# Appendix 5.8

## **NE DAS Response**

**Discretionary Advice Service (Charged Advice) 6742/312493**

**Development proposal and location:** Time extension for implementation of granted Development Consent Order (DCO) for the North Killingholme Power Project.

Chart 3-12 - Curlew Counts for Winter 2019/2020

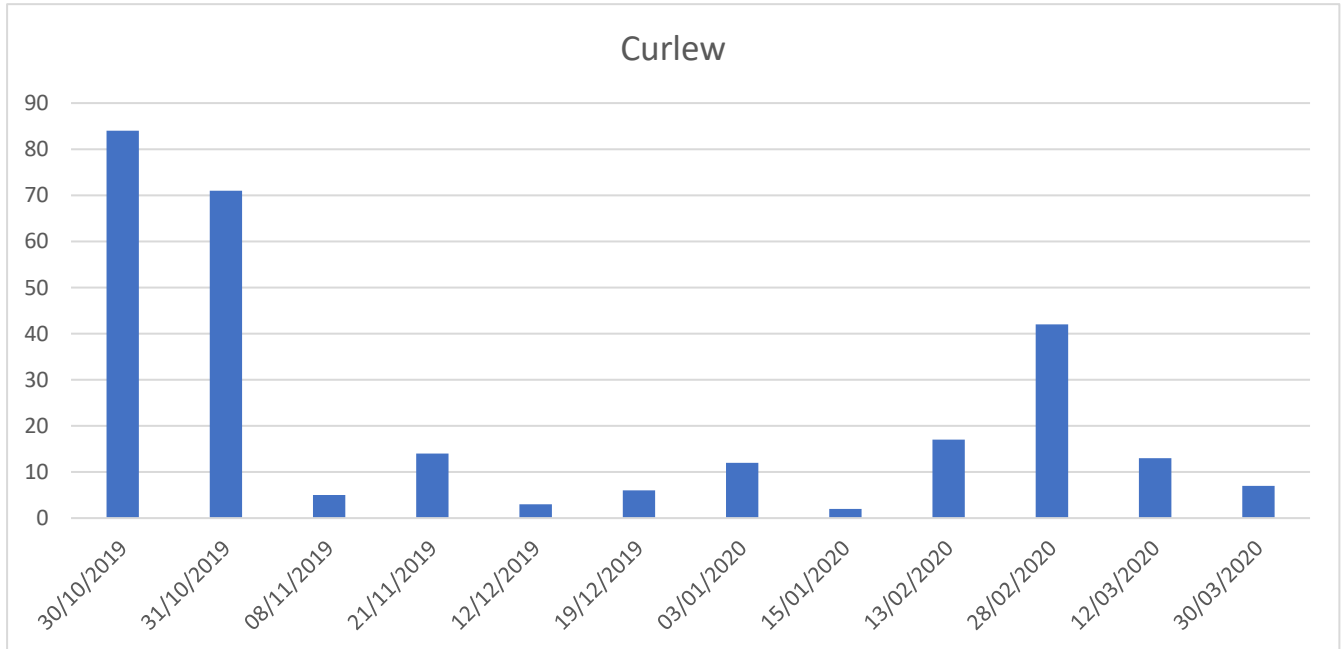
We note as part of the wintering bird survey report that some of the charts that have been provided do not appear to correspond to the text for the species numbers recorded, e.g. 3.6.88. Whilst we understand the complexities of presenting the amount of data that is available, we consider that it would be helpful to provide a summary table for each species highlighting the results from the various datasets. Currently, it is extremely time consuming going through each species individually to assess if there have been any changes. In addition, to reiterate, we recommend that as the original surveys are not publically available, this data needs to be provided.
